Ribble Valley Borough Council  
Housing & Development Control

Application no: **3/2020/0867**

Address: **Bowland Wild Boar Park Wardsley Road Chipping PR3 2QT**

Proposal: **Discharge of condition 6 (Construction Management Plan) from planning permission 3/2020/0579**

Site plan

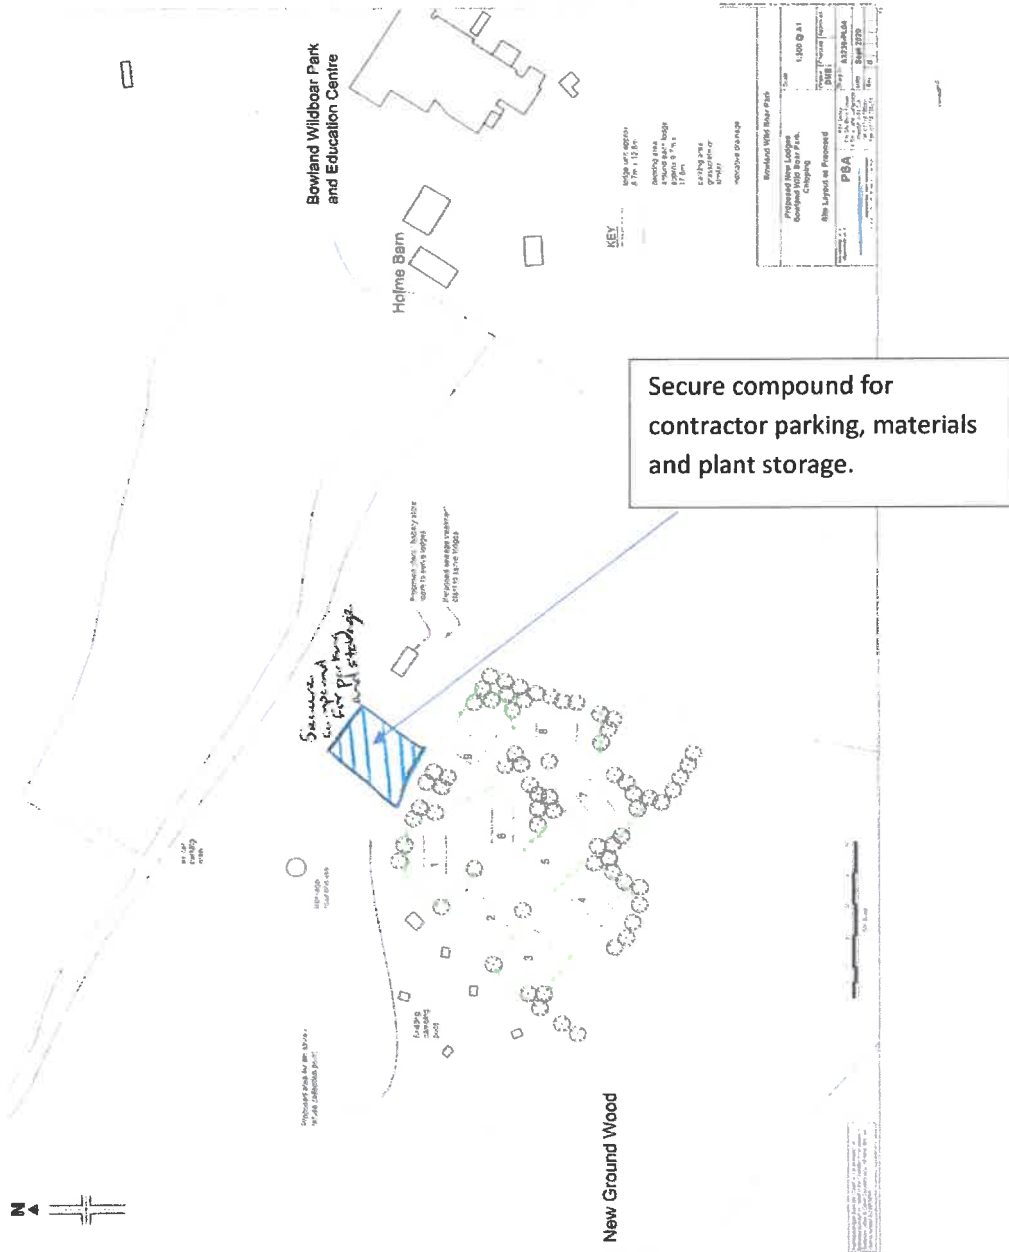
Within the delivery of materials and plant section of the construction method statement it also refers to materials being transported "where possible" by smaller HGVs, the delivery section also refers to large vehicles being escorted to site but does not bare any reference towards the expected size of those large vehicles. Furthermore, deliveries to site must be out of peak hours due to the nature of the surrounding road network.

The construction method statement must also fulfil all of the required criteria set out within condition number 6 with not just a proportional effort, as to fully discharge this condition despite those concerns raised above, would be considered premature given the applicant has not fulfilled the full criteria of the condition.
